Subject: RE: Planning Consultation on: CM/48/21/RES

Application No: CM/48/21/RES

Site Address: Land to the West of Church Lane South of Horsemere Green Lane Climping

Planning Reference: CM/48/21/RES – Outline Conditions - Planning Conditions 9, 10 and 11

Drawing Status	PLANNING		
Client	Vivid and Climping Homes		
Project	Land adjacent to Church Lane, Climping, West Sussex		
Drawing Title	Proposed Drainage Sheet 2 of 4		
Scale	1:500	Date	Aug '21
		Drawn By	SPB
		Checked By	MJA
Drawing No.	D1886-002		
		Rev.	B

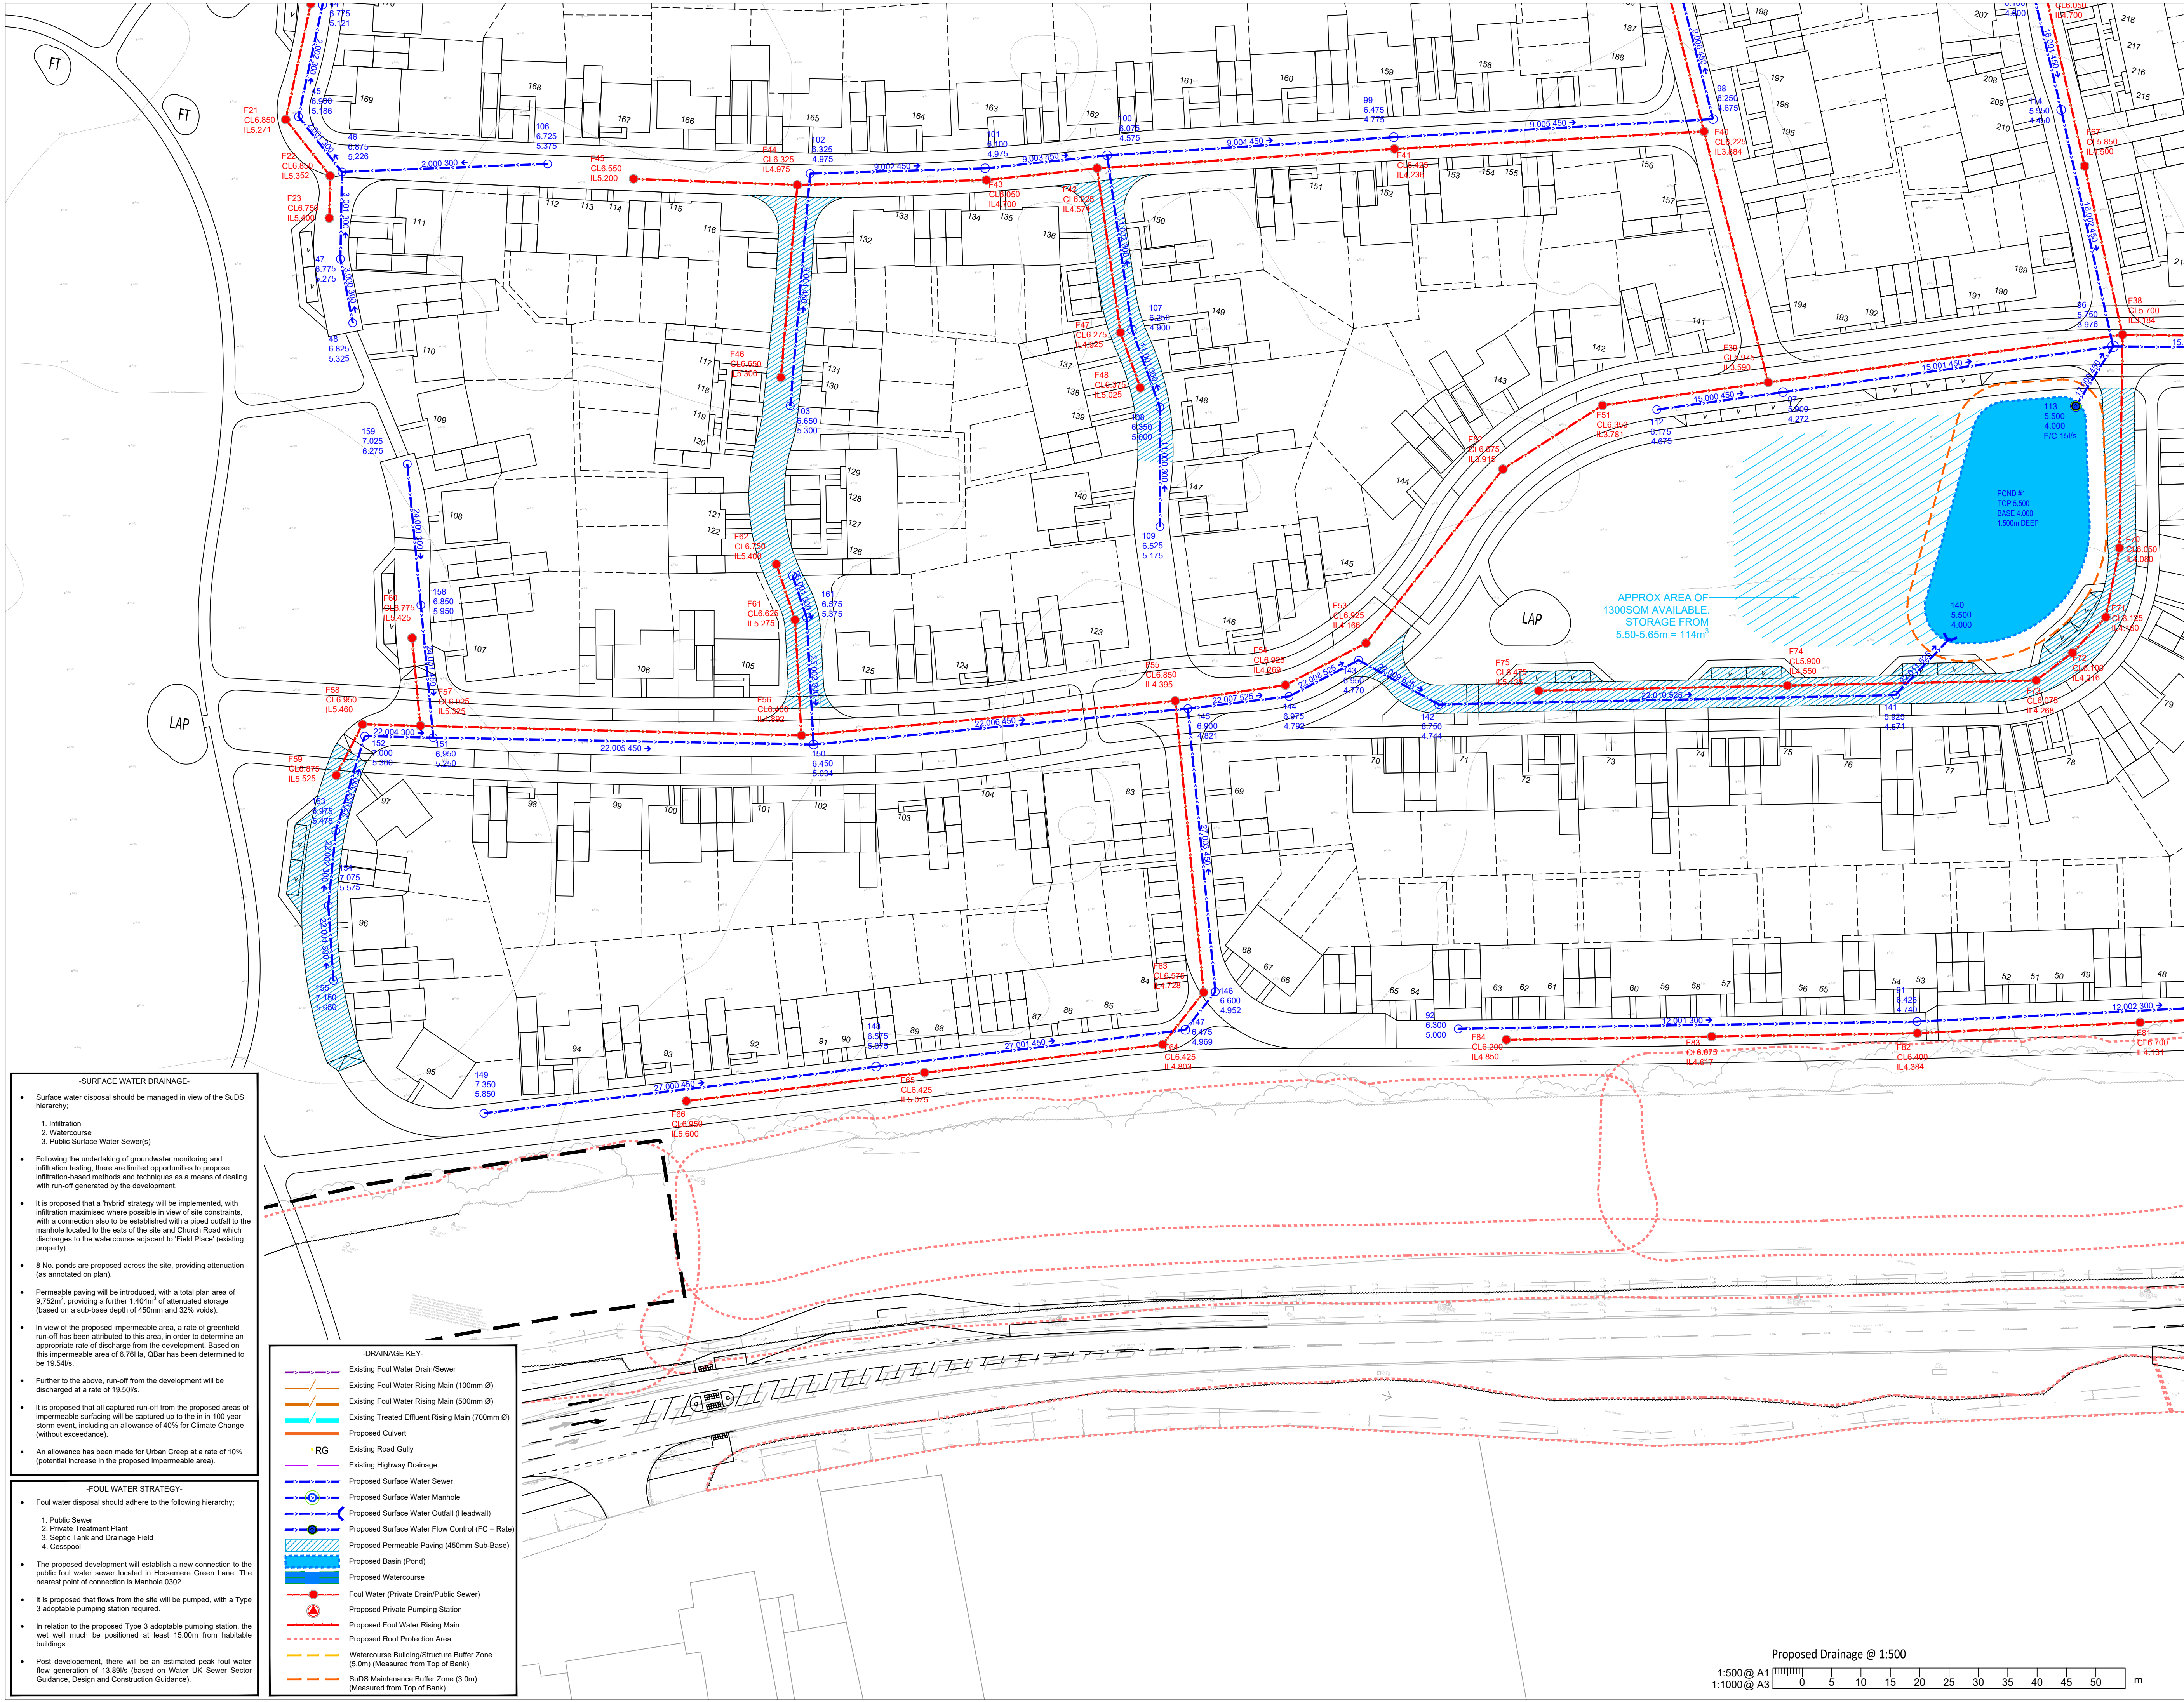
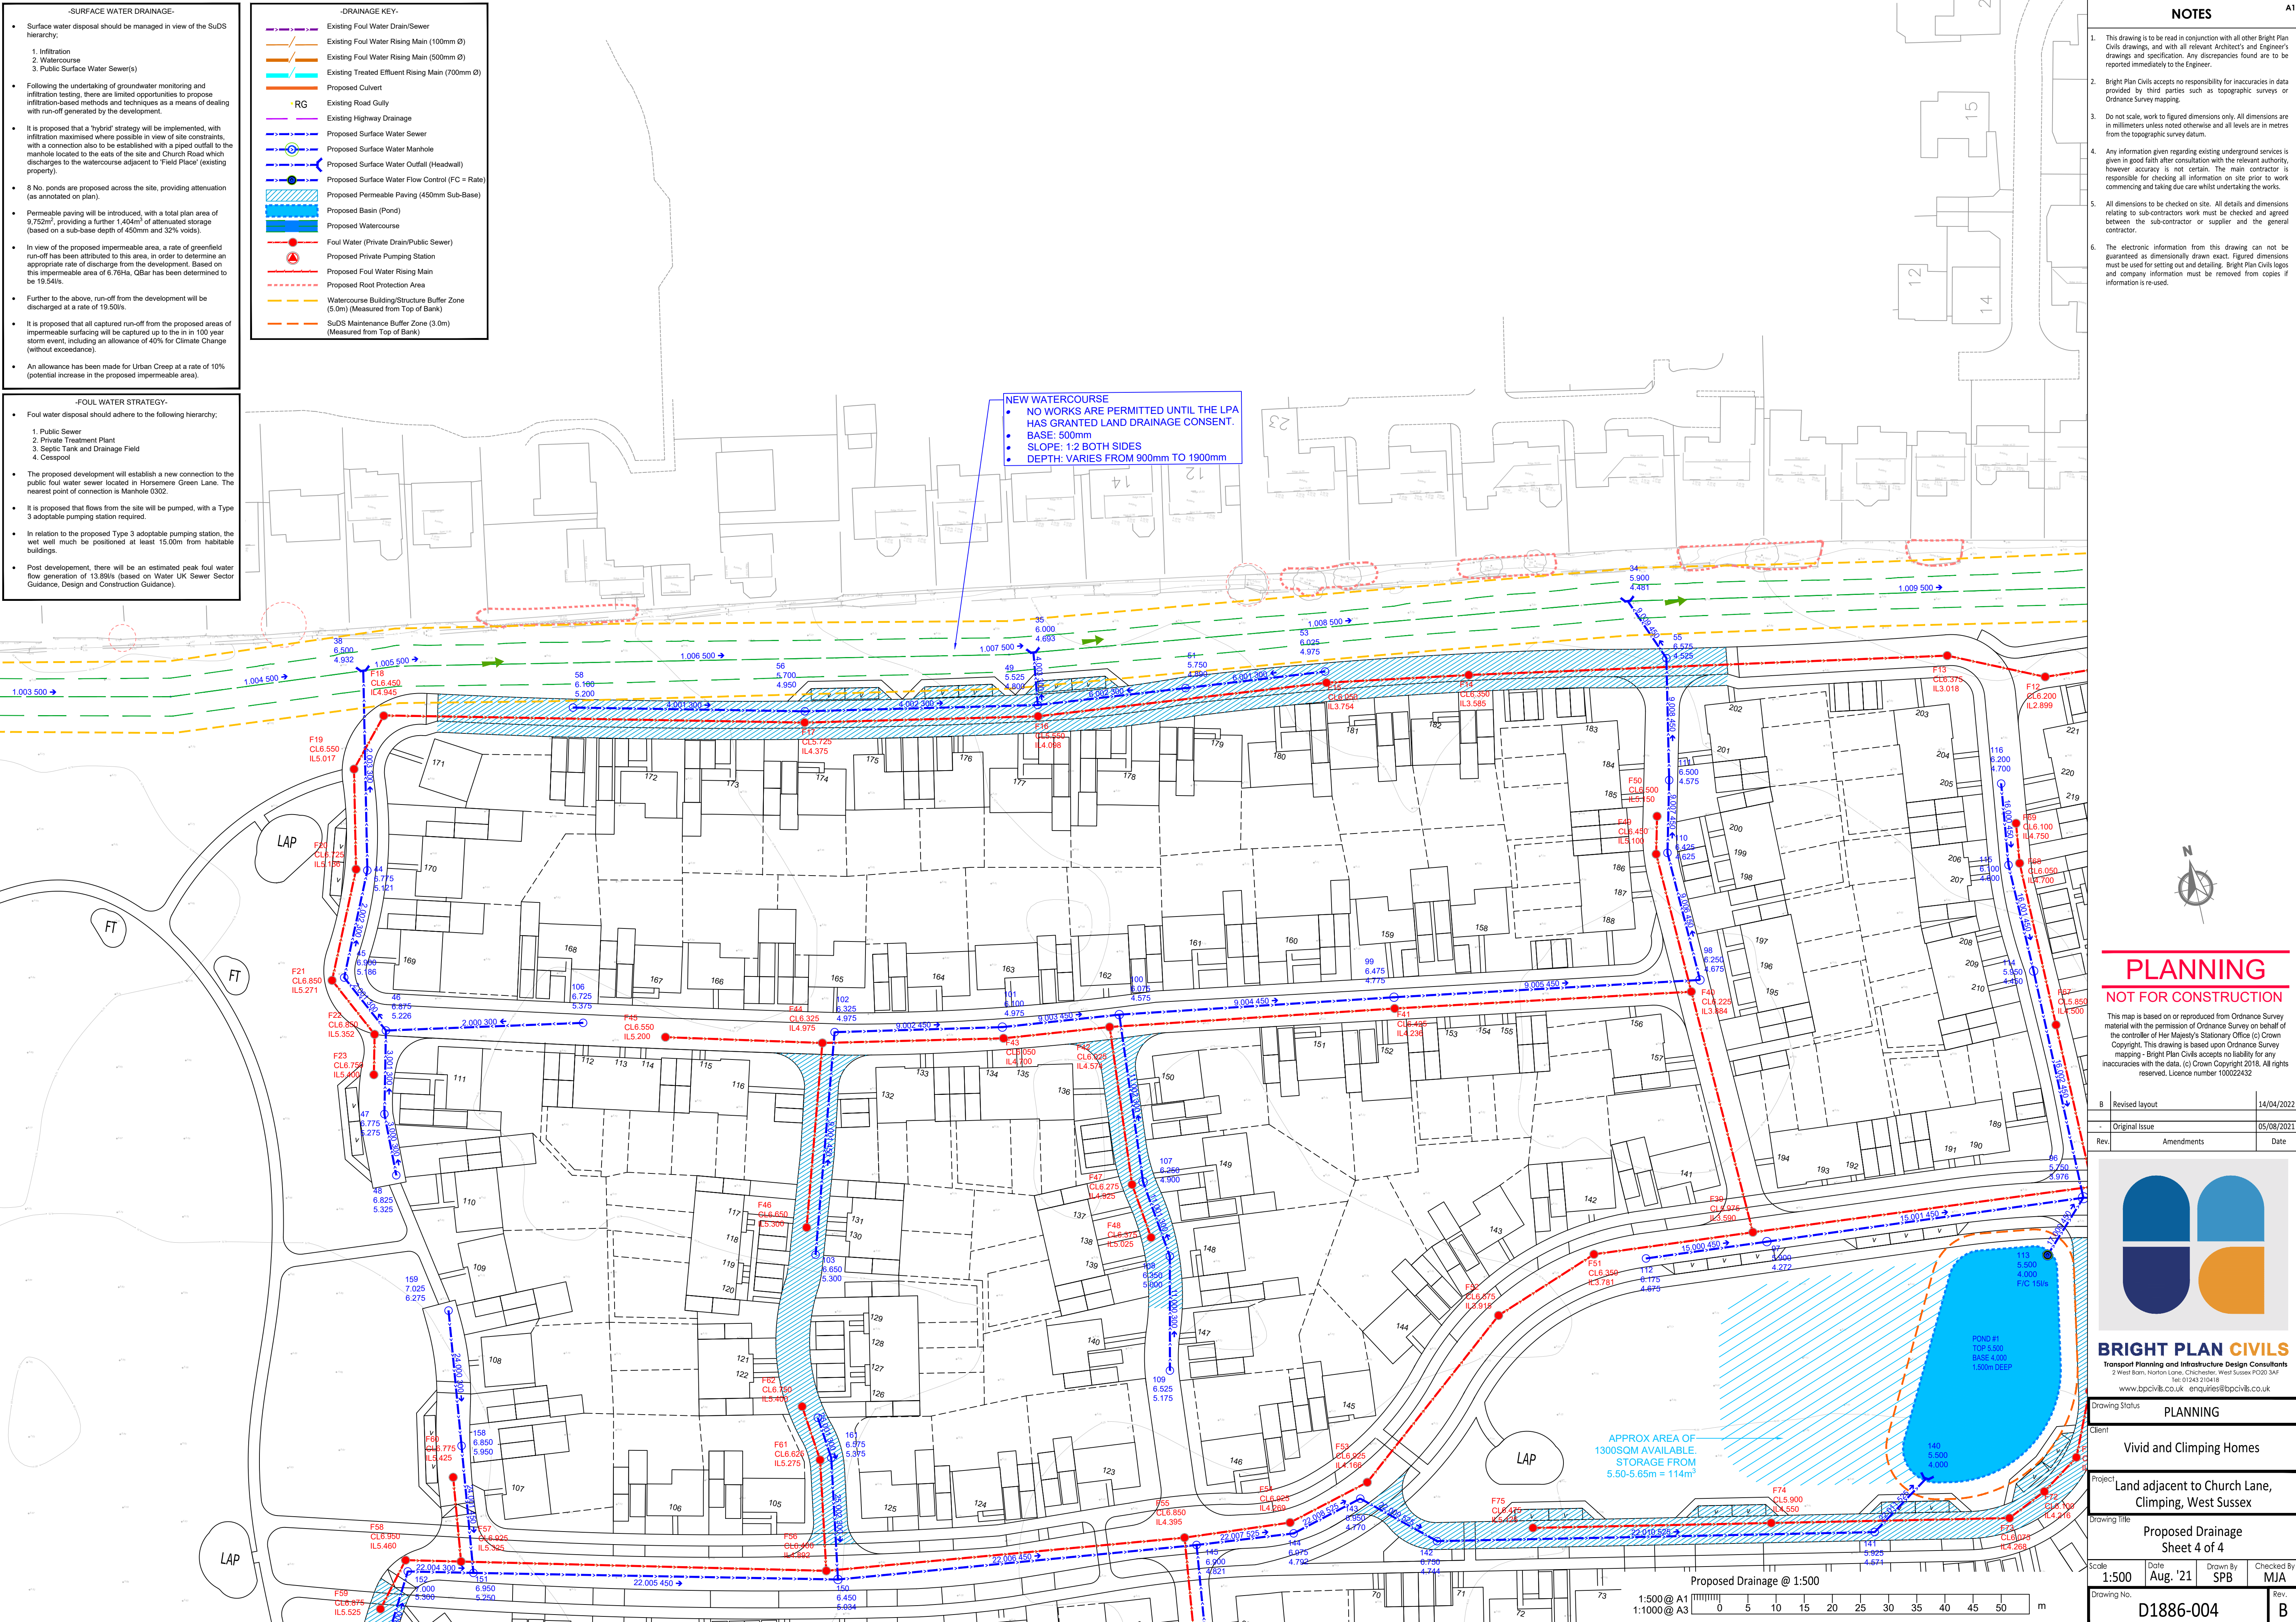
Comment Reference	Comments / Actions	Date	1 st Designers Response	Date	Comments / Actions	2 nd Designers Response	Comments / Actions	3 rd Designers Response	Status
1	You have previously provided cross-sections of the proposed basins. The cross-sections confirm that a number of the ponds do not provide adequate freeboard. These are as follows; Basin 2, Basin 5 and Basin 6. Freeboard is required to; provide resistance against failure, to account for uncertainties in design (there is a very large degree of uncertainty with hydrology), allow for errors in construction, and to account for erosion or settlement of raised banks. A minimum of 150mm freeboard is required within the basins for the 1:100+40% rainfall event. Please update the basins to provide this.	24/10/2022							
2	Buoyancy calculations are required for all basins based on the updated basin design and recorded groundwater levels at the site together with details of the depths of material required to combat flotation. The calculations must take account for the total depth of the impermeable liner and not just the invert of the basin to determine displaced groundwater.	24/10/2022

10	The impact of groundwater needs to be considered for the proposed swale. Should the swale be located within the groundwater, how will ground water be prevented from entering the swale? Buoyancy calculations will need to be provided should the swale be proposed as lined.	24/10/2022																	
11	No calculations or specific details for the Highway Drainage system that serves the proposed offsite works has been provided at this stage. The flow rate into the watercourse and storage requirements will need to be provided to allow an assessment on if these proposals can be accommodated in the proposed drained design and overall strategy.	24/10/2022																	
12	The outfall pipe from the onsite system should avoid where possible the RPAs of the existing tree. Please revise.	24/10/2022																	
13	Please provide a commentary on the exceedance storage area and how these will work in terms of levels compared to the ponds. Inverts of the headwalls (inflow / outflow?) and other details are required.	24/10/2022
